08 August 2011

**Re: MP 10\_0189 Residential Development at the Royal Rehabilitation Centre  
Sydney**

Sydney Water provides the following further comments for the Department's consideration. Water and wastewater extensions will be required to service the proposed development, as outlined below.

PROJECT **FRASERS PUTNEY RESIDENTIAL DEVELOPMENT**
CHARLES STREET, RYDE
 TITLE **SERVICES CO-ORDINATION PLAN**
- SHEET 2
 PROJECT No **104479-03-MIE22** DRAWING No **A**

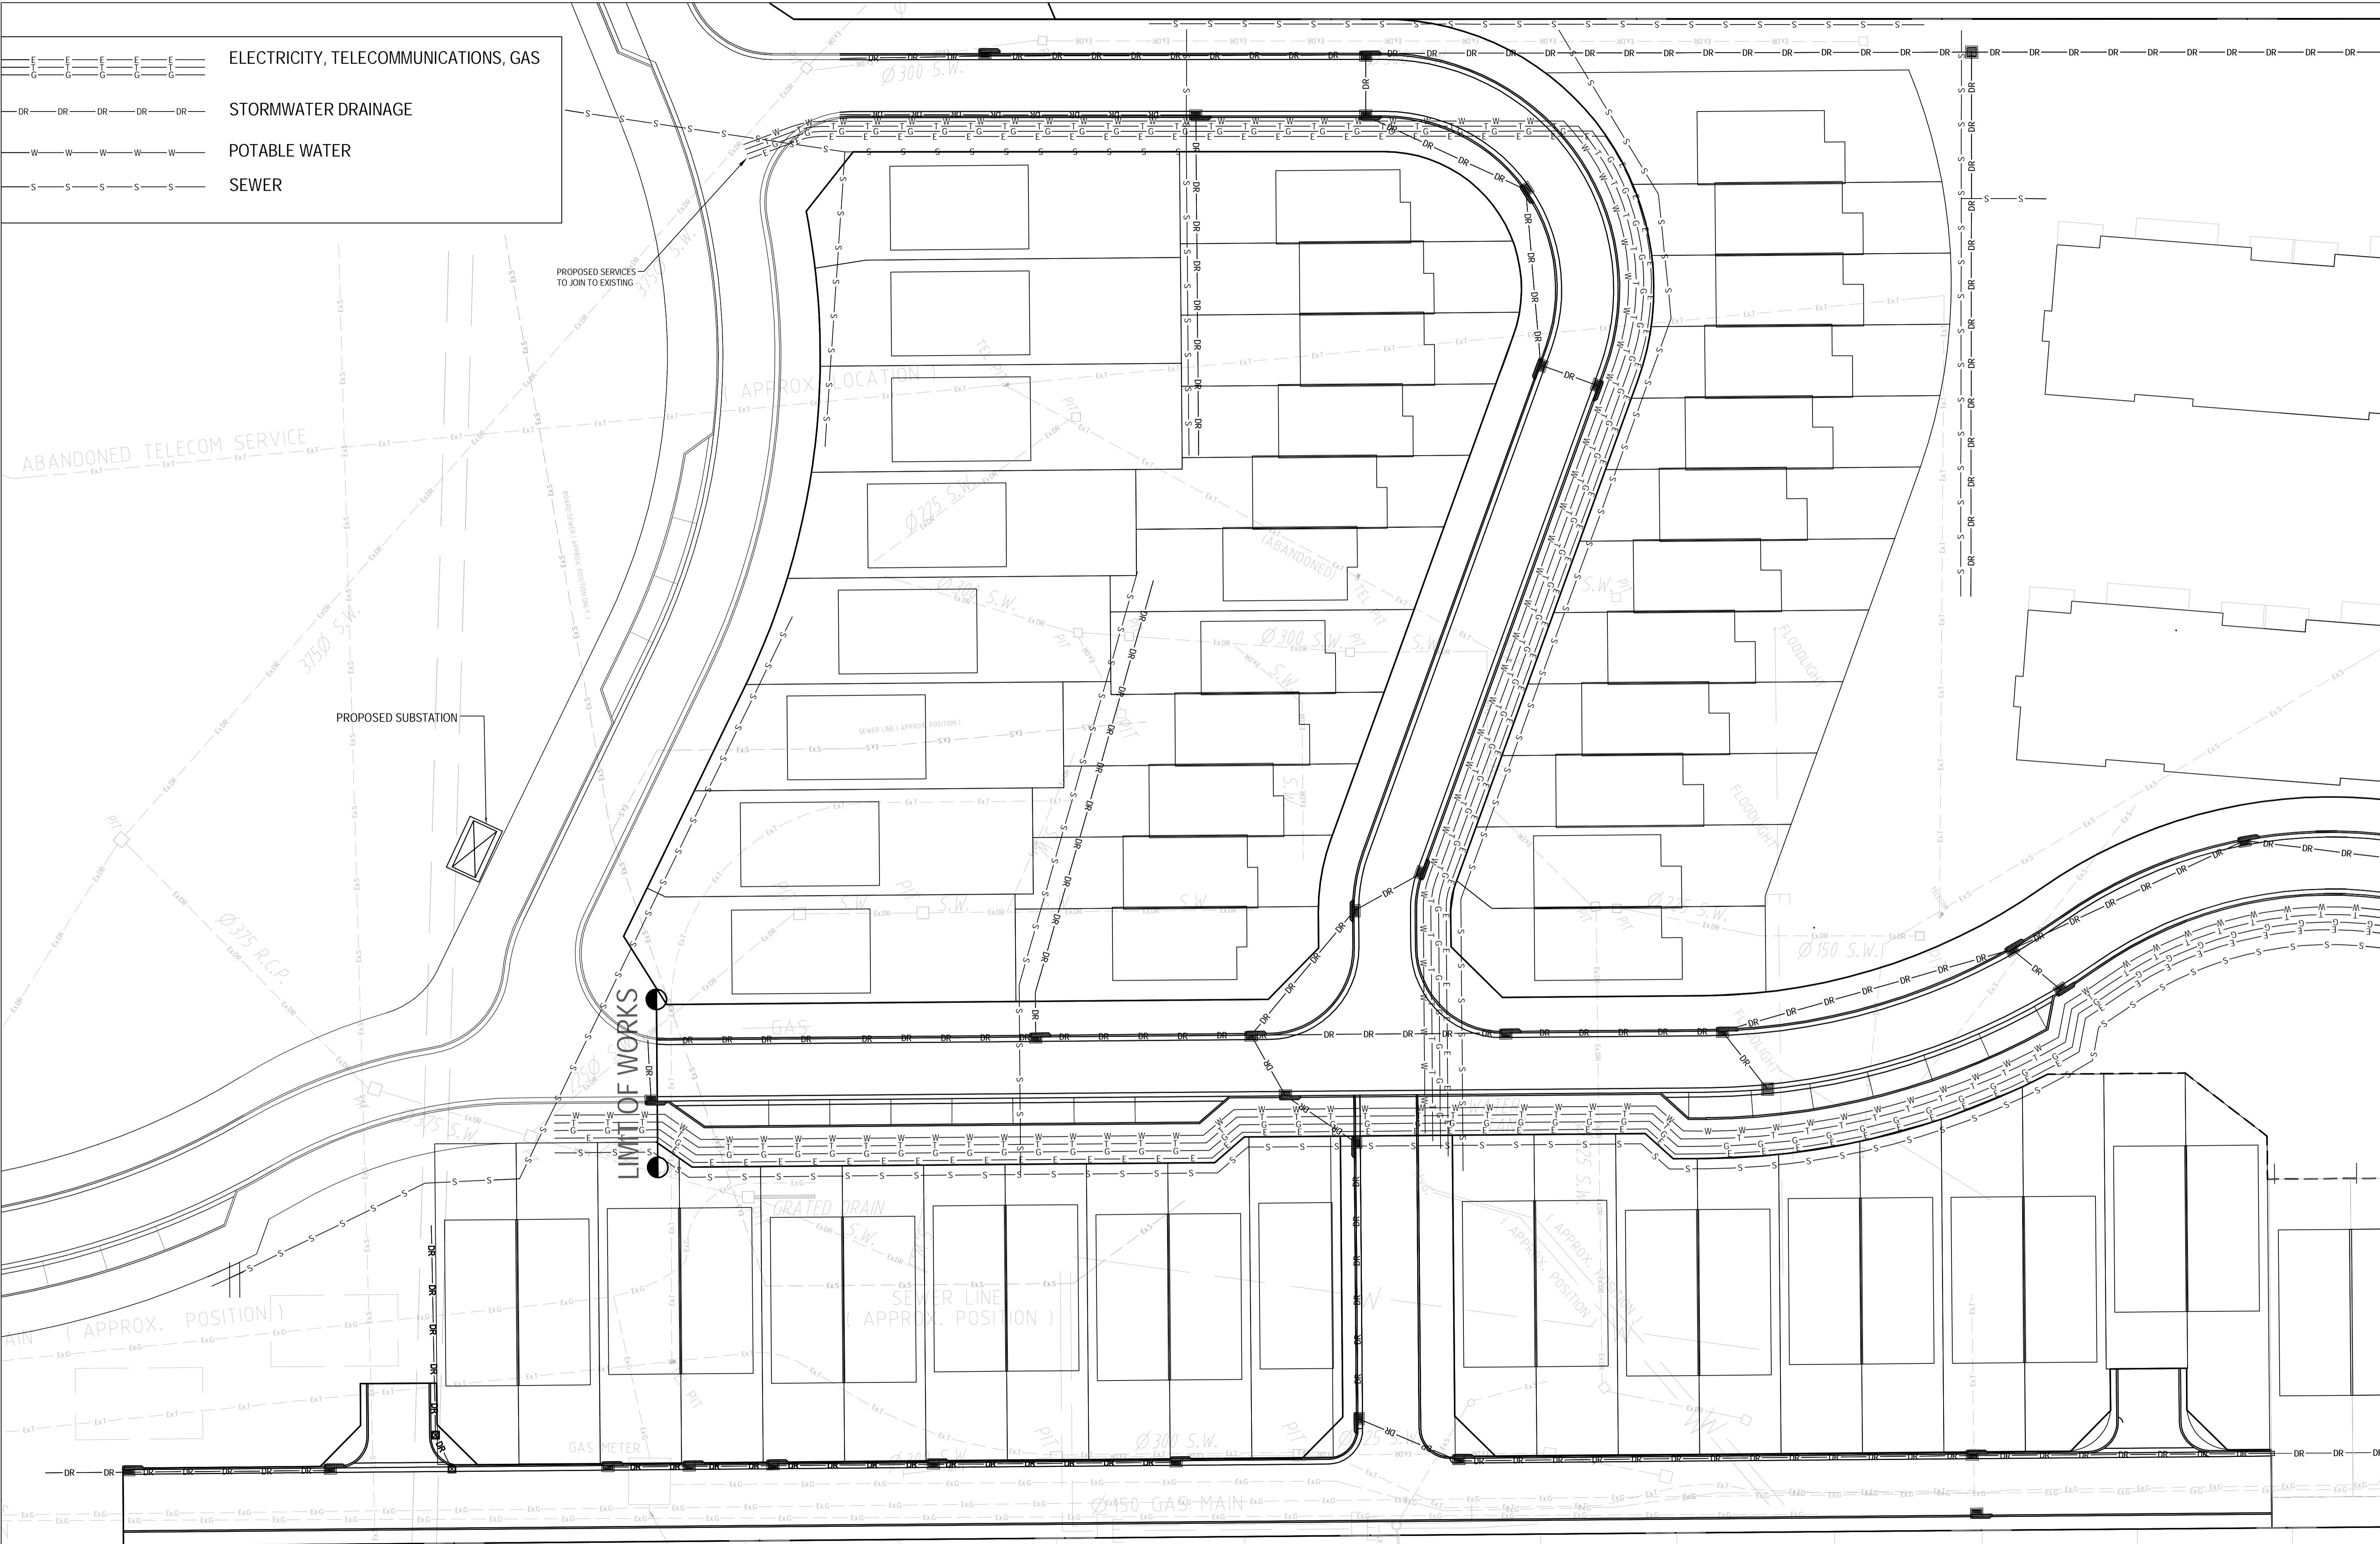
The proposed development conflicts with the location of the 150mm wastewater main traversing the property and the Northern Beaches Ocean Outfall. A wastewater deviation may be required.
